**Office of
Environment
& Heritage**

I refer to your letter received 7 August 2012 inviting the Office of Environment and Heritage (OEH) to provide comment on the Environmental Impact Statement for a Development Application for Stage 2A for the North Penrith Mixed Use Development (SSD 5243).

Office of Environment and Heritage Comment on Stage 2A North Penrith Mixed Use Development (SSD 5243)

Drawing Title: SITE REGRADING PLAN - SHEET 02 OF 02

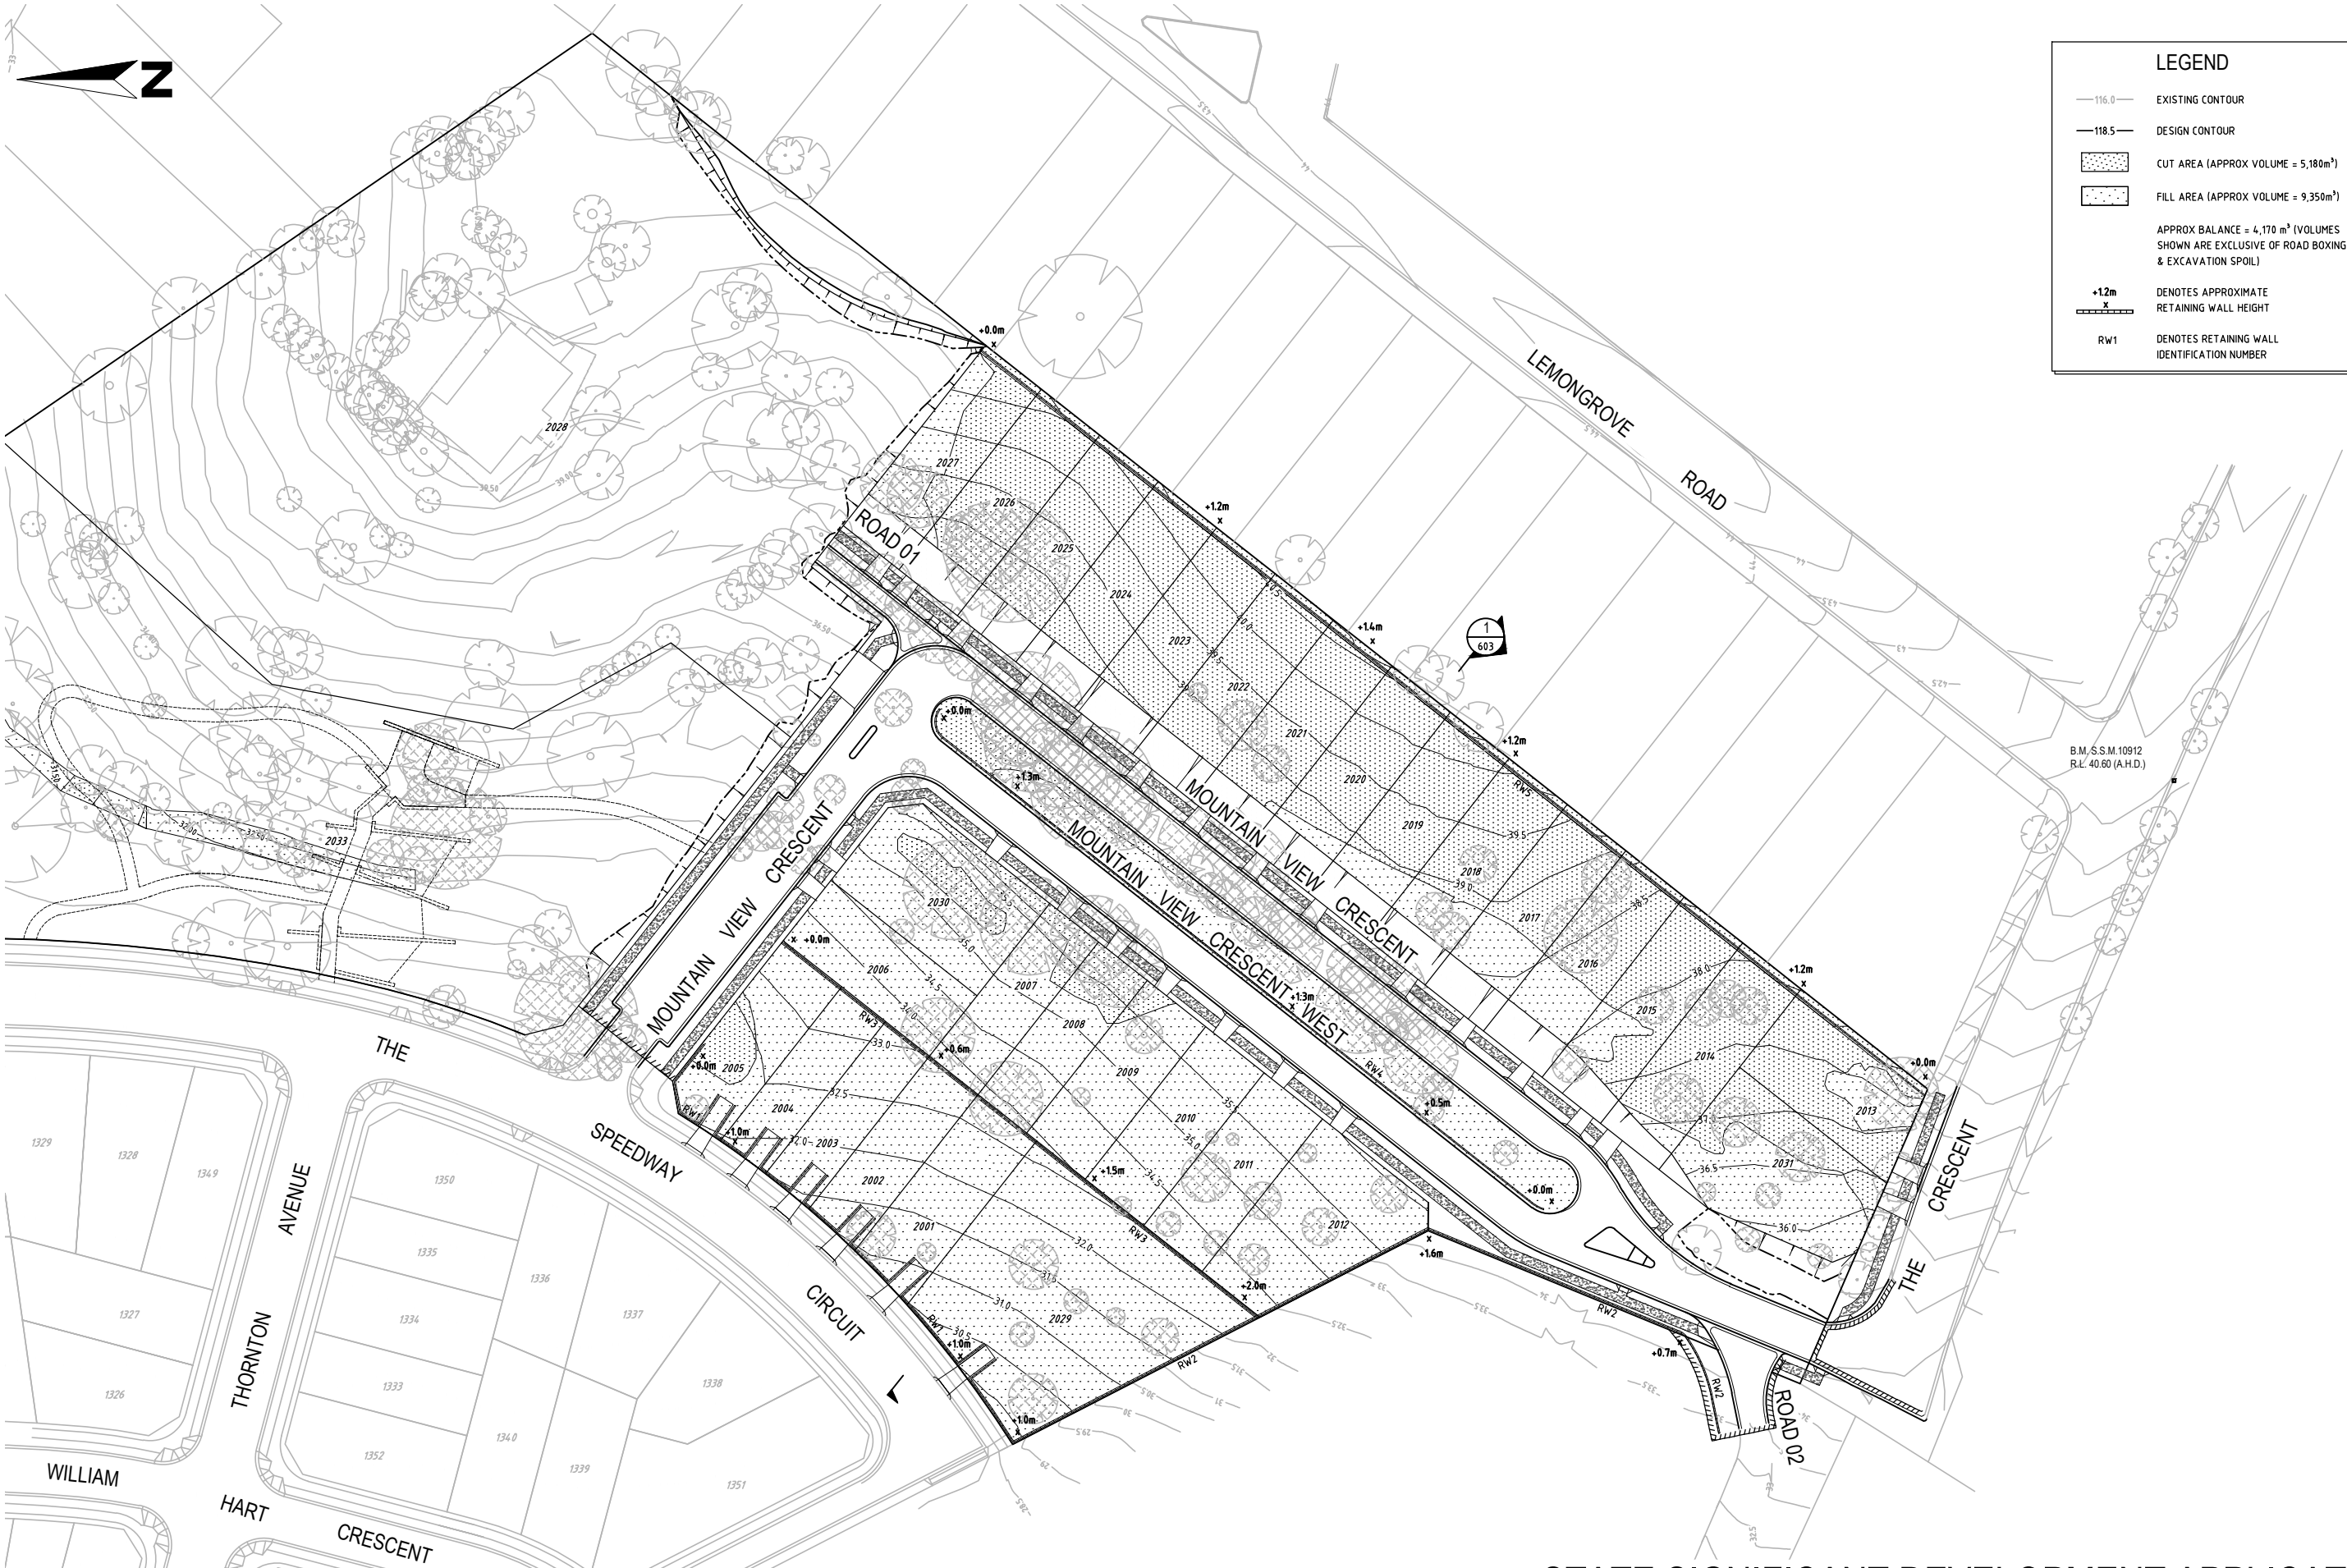
OEH is concerned that the Site Regrading Plans (sheets 01 and 02) show fill and regrading for areas in both Block C3 and OS2 that are expected to have consequent impacts on CPW. Some of these areas are mapped as requiring consultation on Aboriginal and ecological issues. Other infill areas will also impact CPW and remnant trees in the southern part of C3 and in OS2 but have not been flagged as requiring consultation. For example the infill area is shown cutting across much of the CPW in OS2 that was indicated would be retained.

- The areas of CPW in C3 and OS2 should be protected as per the commitments made at Concept Plan stage. There should be no regrading or fill works within at least a 3 metre radius of trees and shrubs that were identified in Figures 11 and 12 of the Flora and Fauna Assessment prepared by Lucas McKinnon for the Concept Plan as being either CPW *"Existing Trees to be retained"* and *"shaded Cumberland Plain Woodland with the C3 will be protected via section 88b instrument"* respectively.
